Our ref: NO/2012/103817/02-L01
Your ref: 3/2012/0166
Date: 20 June 2012

**PROPOSED CONSTRUCTION OF EARTH BANK SLURRY STORE
SMALLEY FOLD FARM, COMMONS LANE, BALDERSTONE, LANCASHIRE**

Title: Proposed plans, elevations, cross sections, site & location plans.

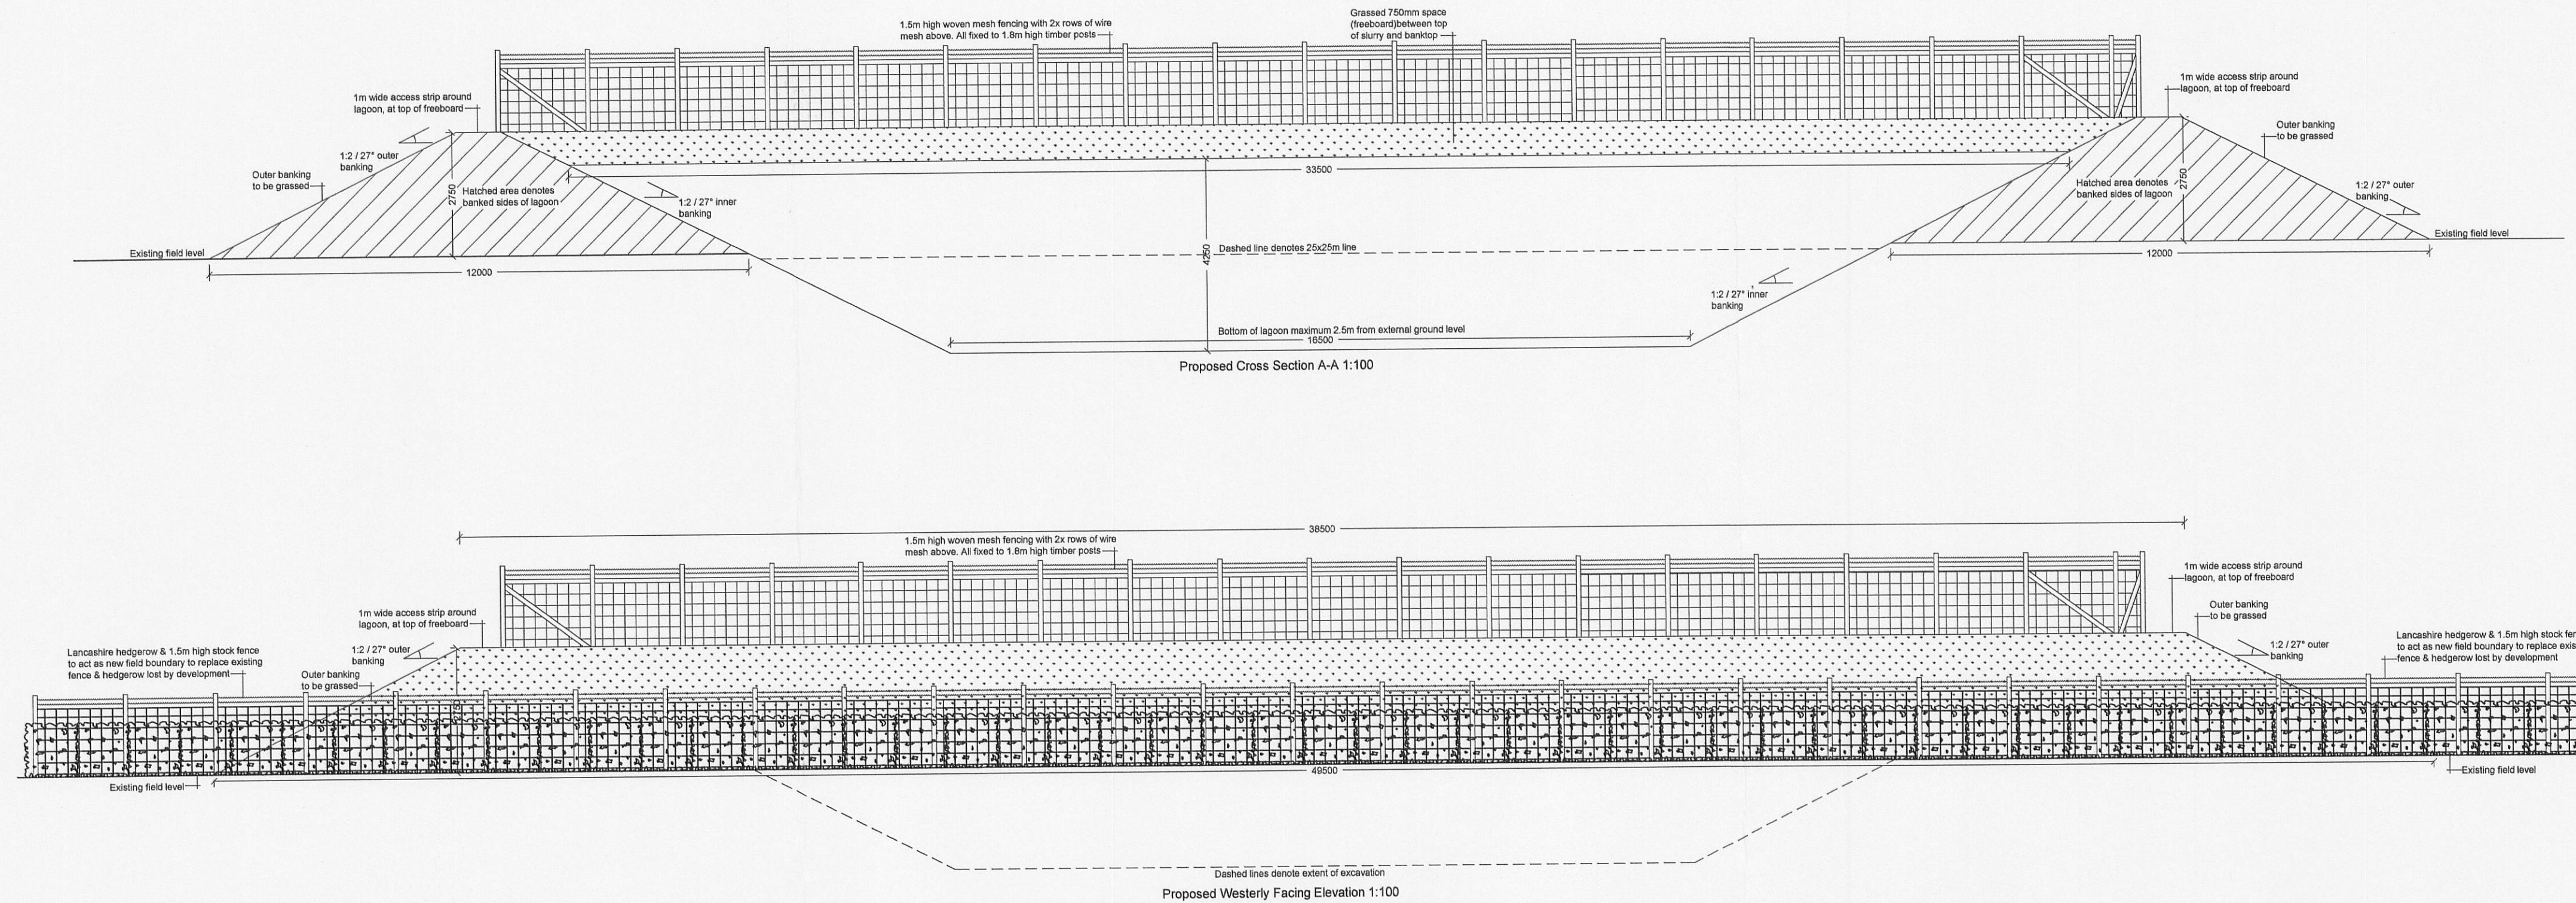
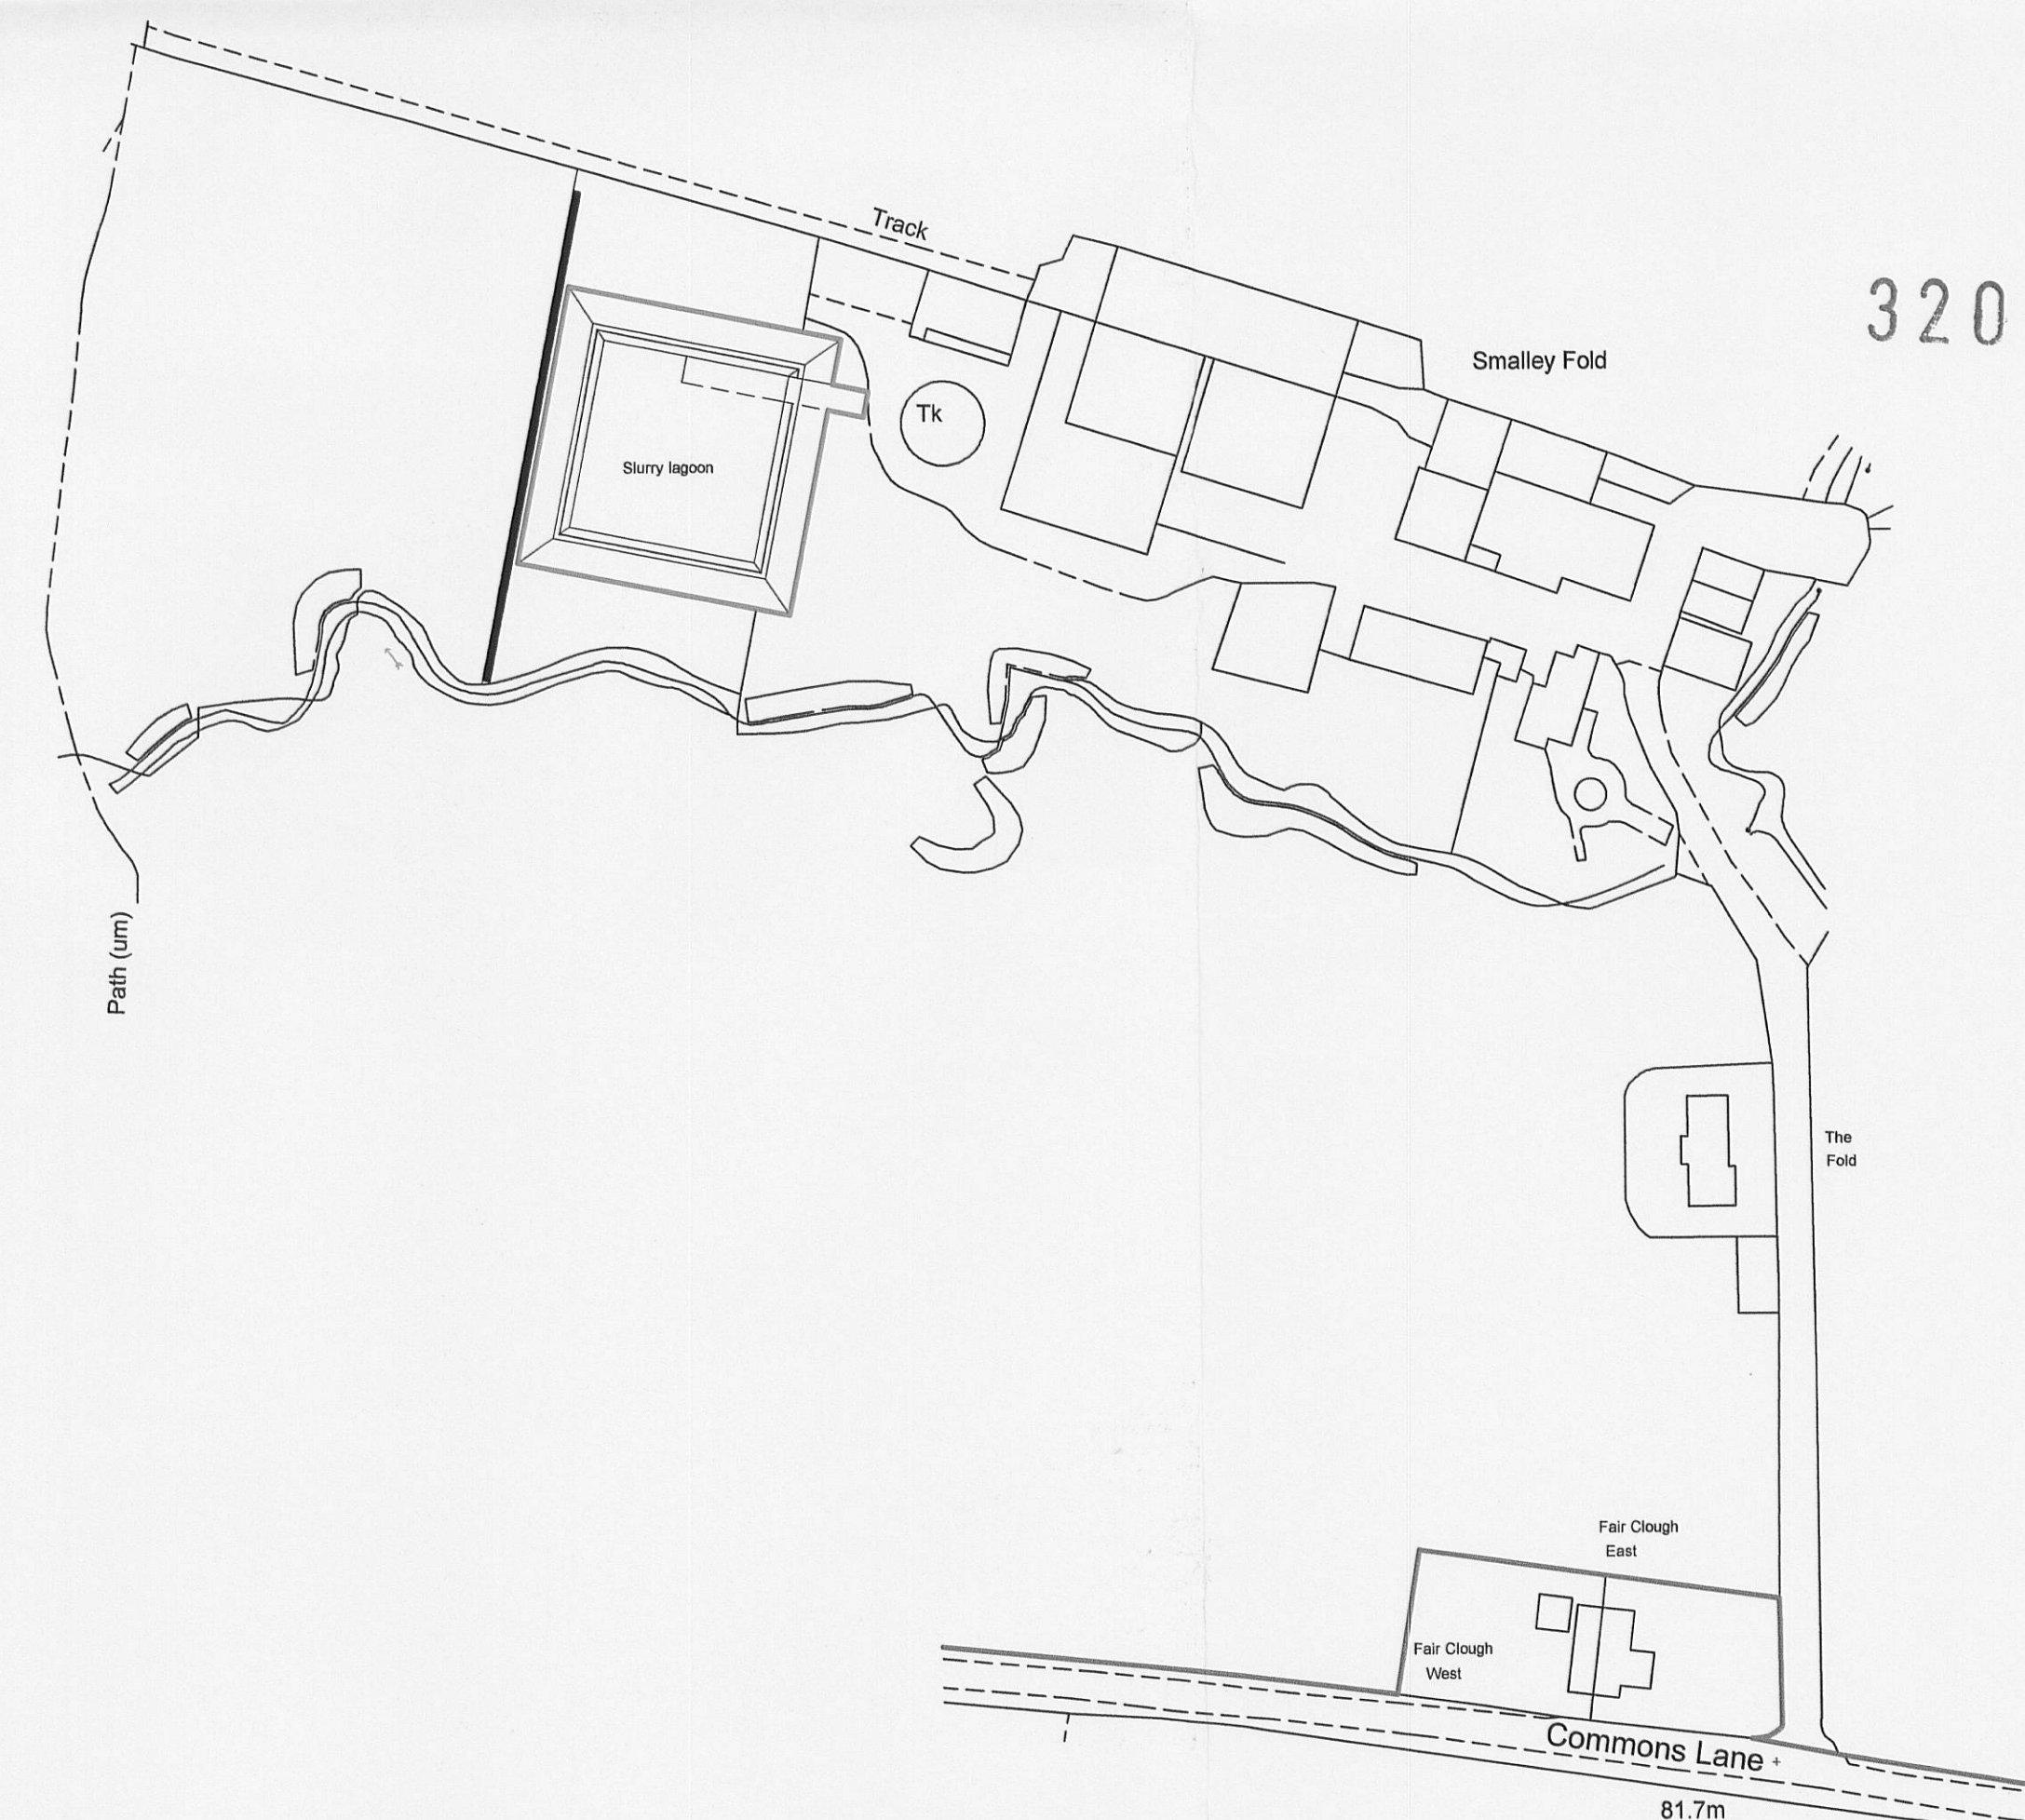
We have subsequently discussed the proposals with the applicant's agent. The permeability tests will determine whether or not the ground conditions are appropriate in the location of the proposed slurry lagoon. However, in a worst case scenario, if the ground conditions were not suitable this could be resolved through the importation of appropriate material or the provision of an impermeable liner within the lagoon. While this is more costly, we understand that the applicant is prepared to do this if necessary to enable the slurry store to be constructed in the proposed location.

The slurry store (in conjunction with any other slurry storage on the farm) should accommodate the maximum quantity of slurry likely to be produced and directed to this system in any continuous four-month period. The calculations submitted as part

of the application state that the proposed lagoon will afford eight months storage capacity, which would clearly satisfy the regulations.

CONDITION Prior to the commencement of development, permeability testing of the ground within the footprint of the proposed lagoon shall be undertaken and the results submitted to the council. Where the in situ soils are not shown to be suitable for the proposed development, full details of a scheme for lining the lagoon with an impermeable barrier shall be submitted to and approved in writing by the local planning authority. The development shall proceed in accordance with the approved scheme
